Explanation of Highway Plans Changes

The West Midlands Rail Freight Interchange Order 201X

Deadline 8 - 21 August 2019

DOCUMENT 18.3 – EXPLANATION OF HIGHWAY PLANS CHANGES

West Midlands Interchange	
Project THE WEST MIDLANDS RAIL FREIGHT INTERCHANGE ORDER 201X	
Drawing Status SUBMISSION	
Drawing Title	Drawing Size A1
SPEED LIMITS PLAN	
KEY PLAN	
Regulation 5 (2) (o)	Document 2.12
Drawn RJM	Date 2017
Scale 1: 5000	Reviewed JF
Drawing No. WSP-70001979-SK-062	Rev. G

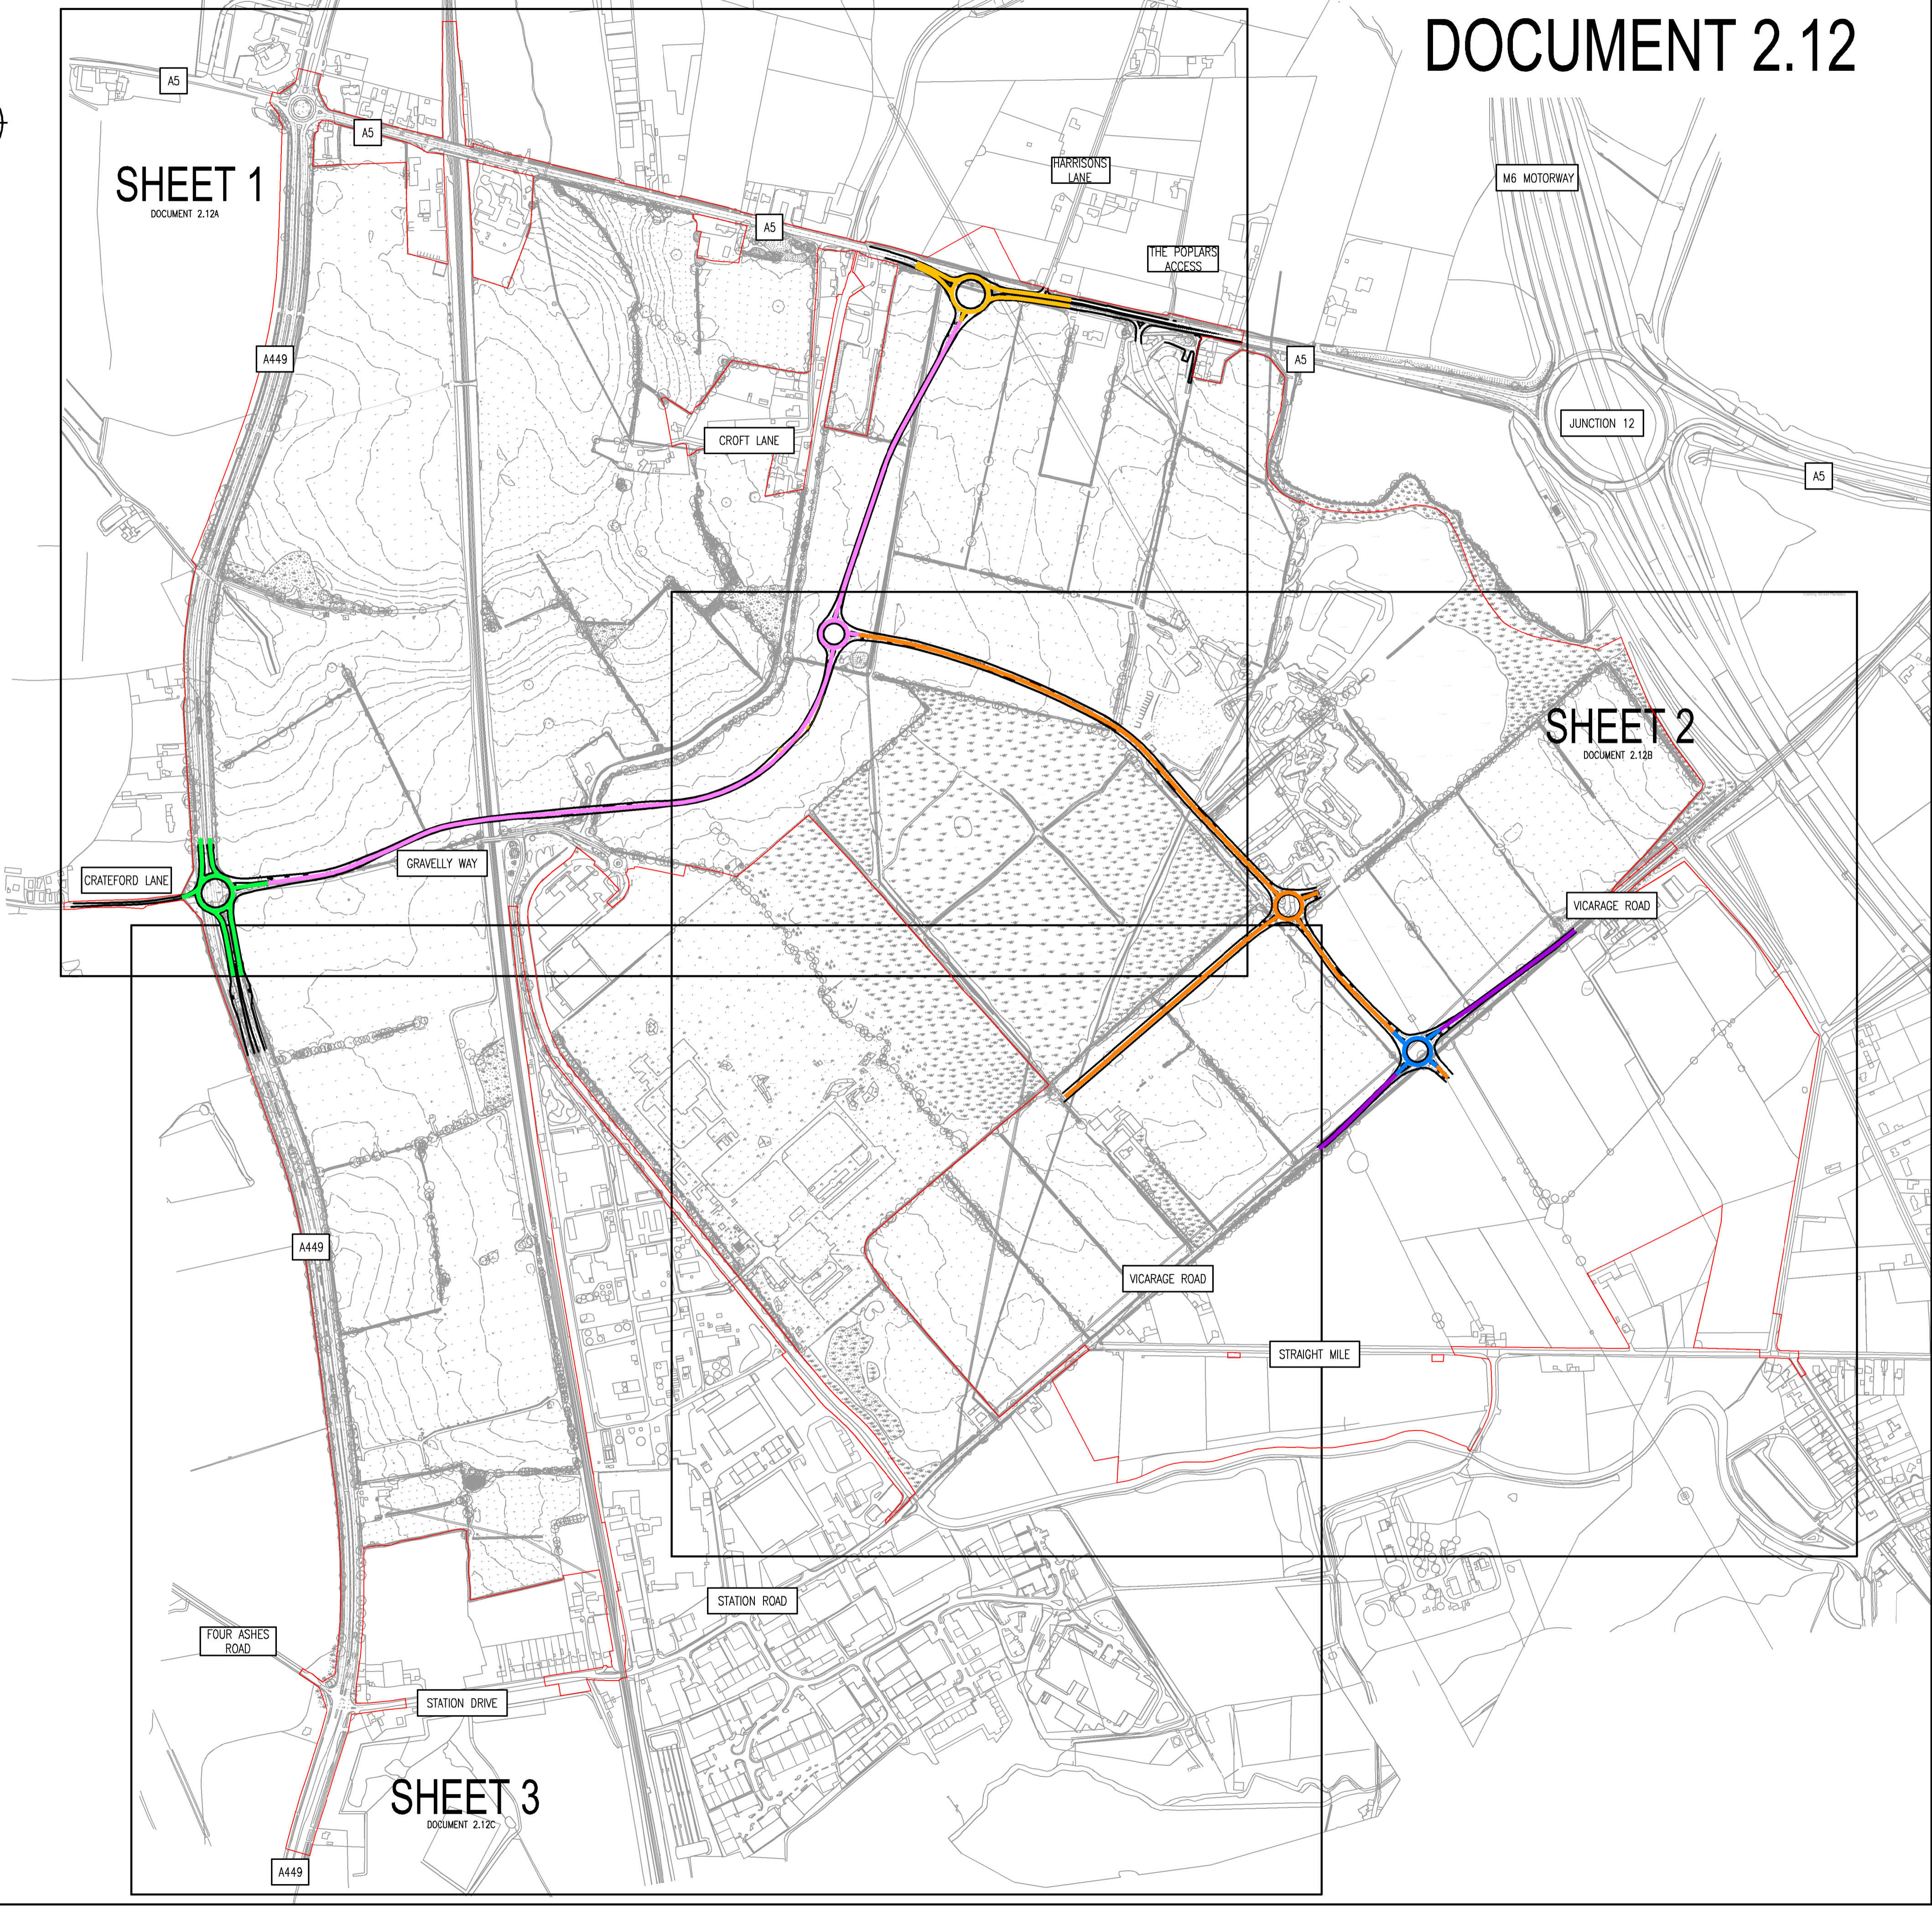
- 2.1 Following results of the final safety risk assessment, the crossing over the A5/A449 Link Road is now proposed to be located nearer to the A449 roundabout to better address the safety risk to vulnerable road users.

- Traffic Regulation Plans (Key Plan (Document 2.11) and Sheet 1 (Document 2.11A));
 - Speed Limit Plans (Key Plan (Document 2.12) and Sheet 1 (Document 2.12A)); and

Project <b>THE WEST MIDLANDS RAIL FREIGHT INTERCHANGE ORDER 201X</b>	
Drawing Status <b>SUBMISSION</b>	
Drawing Title <b>FUTURE HIGHWAY MAINTENANCE PLAN KEY PLAN</b>	
Regulation 5 (2) (o)	Document 2.10
Drawn RJM	Date: JUNE 2018
Scale: 1: 5000	Reviewed JF
Drawing No. WSP-70001979-SK-091	Rev. F

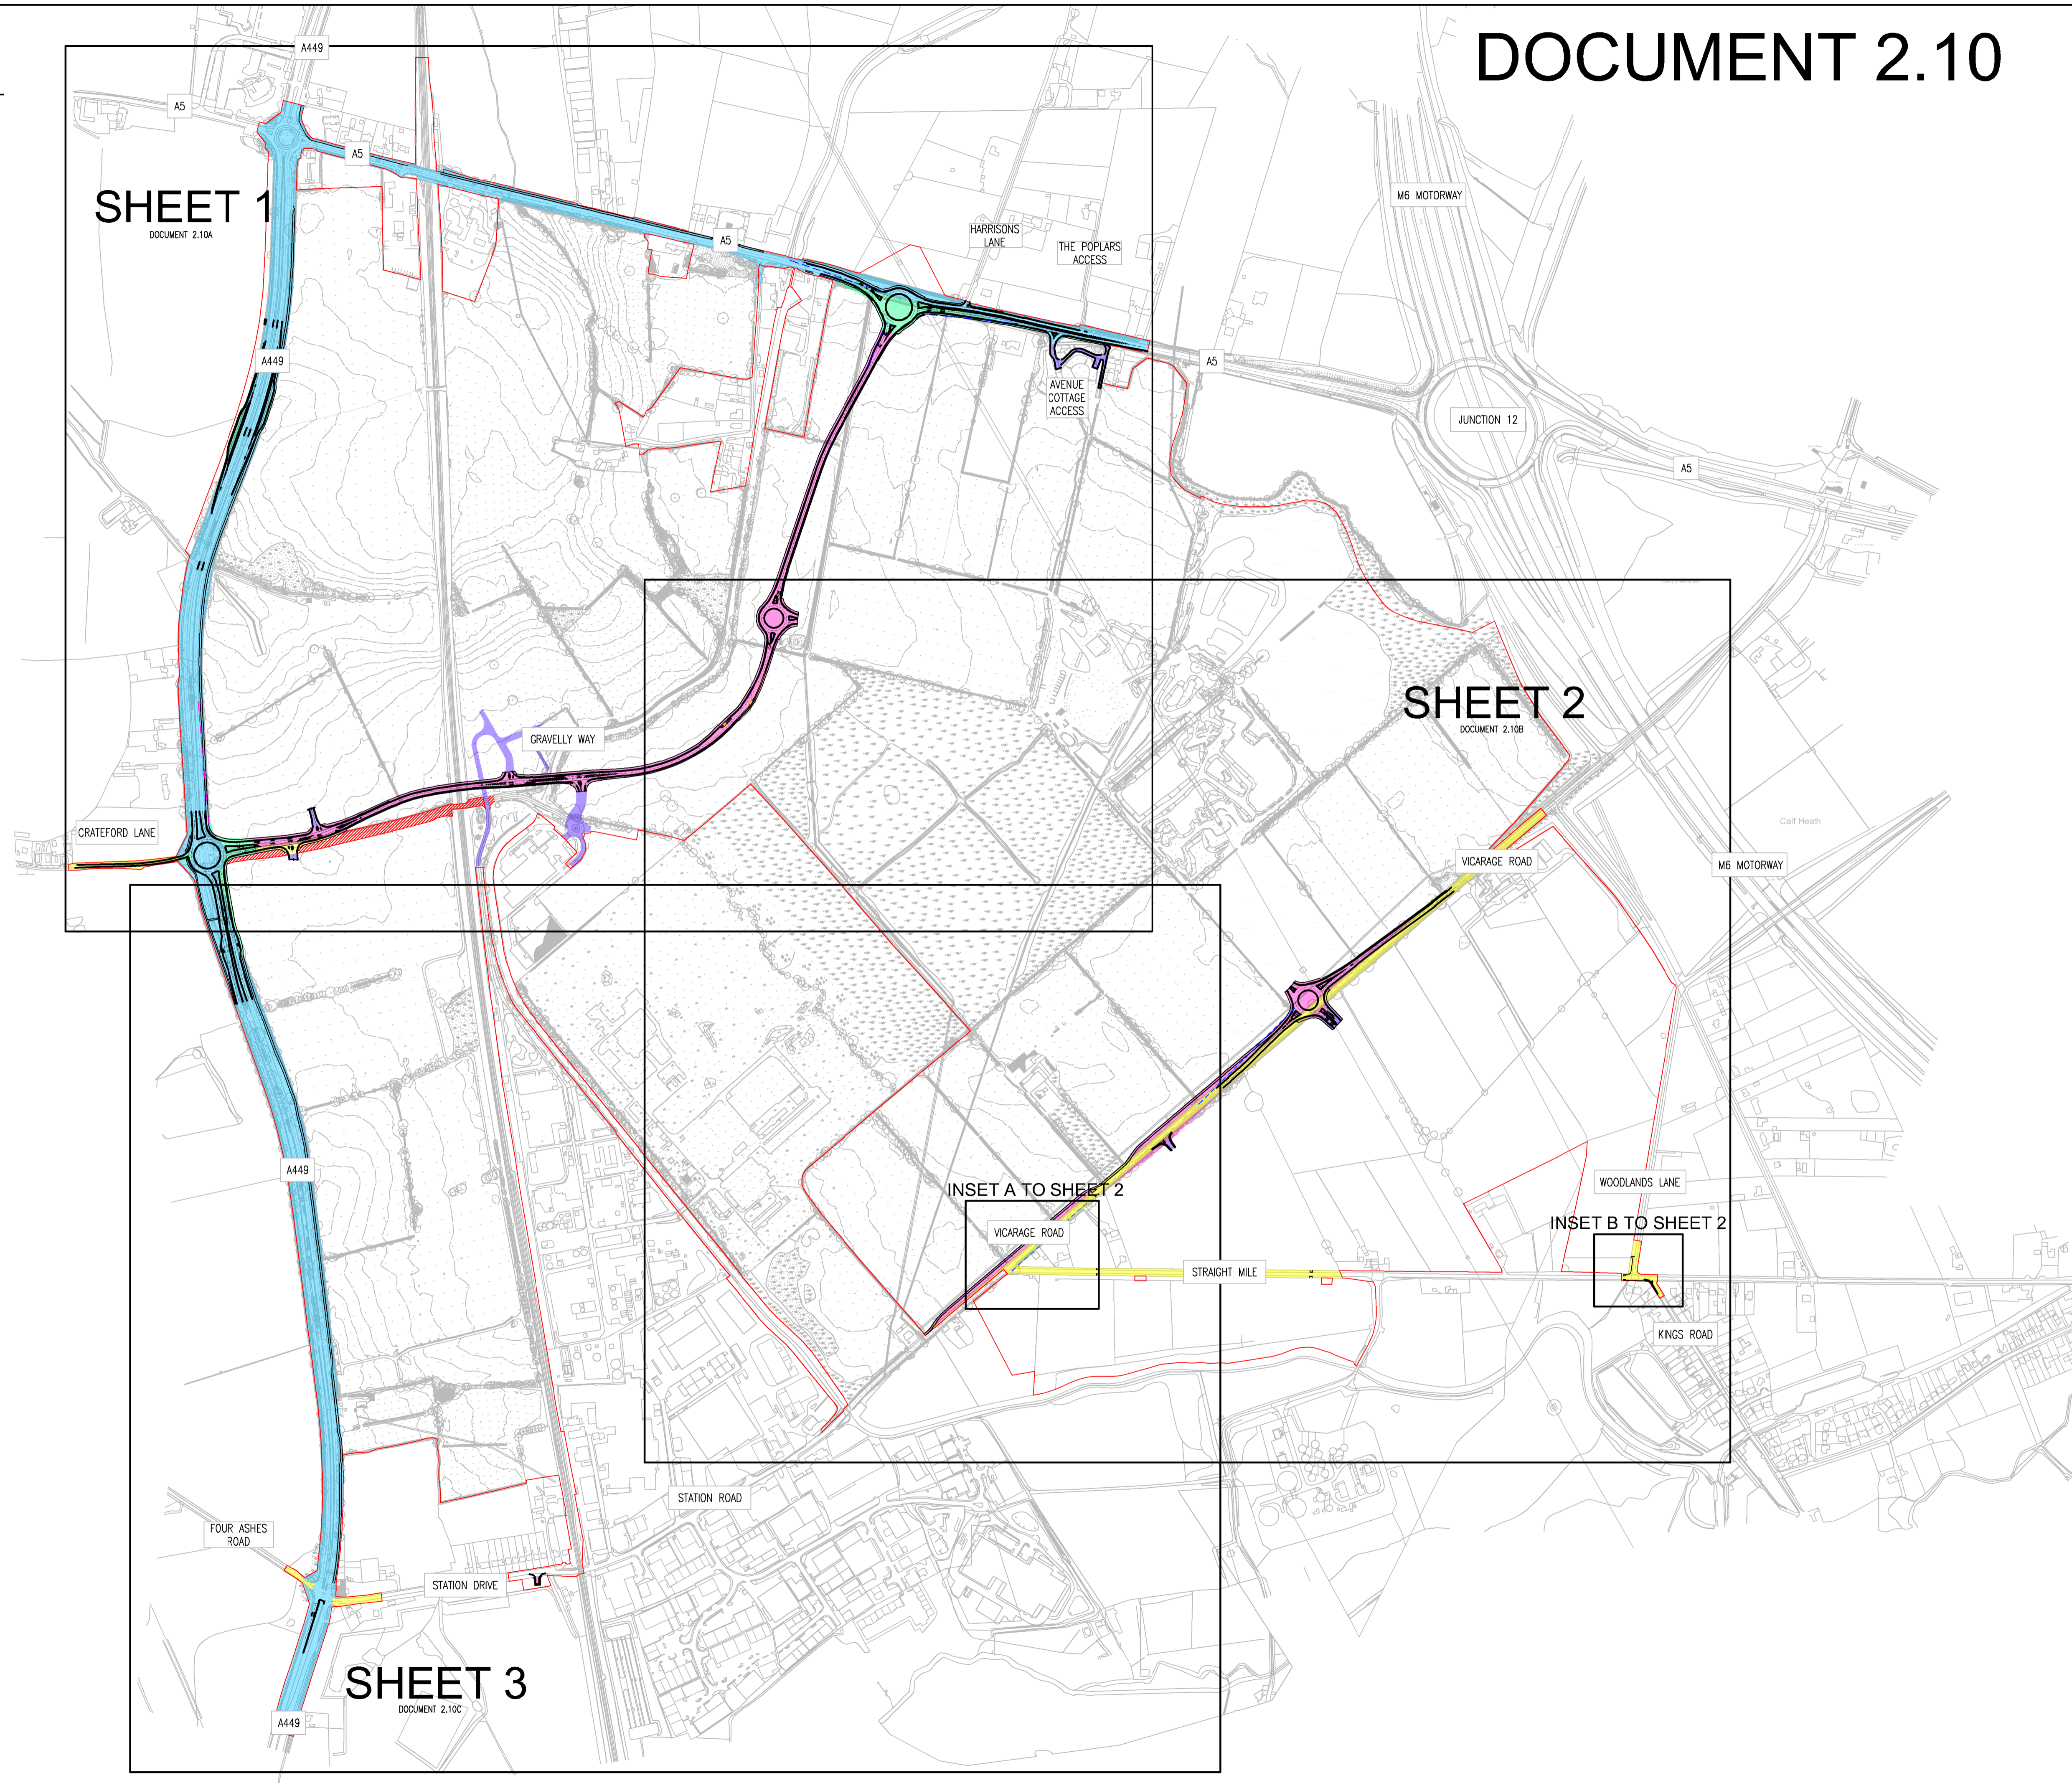
- Highway General Arrangement Plans (Key Plan (Document 2.9) and Sheet 3 (Document 2.9C));
 - Future Highways Maintenance Plans (Key Plan Document 2.10) and Sheet 1 (Document 2.10A));
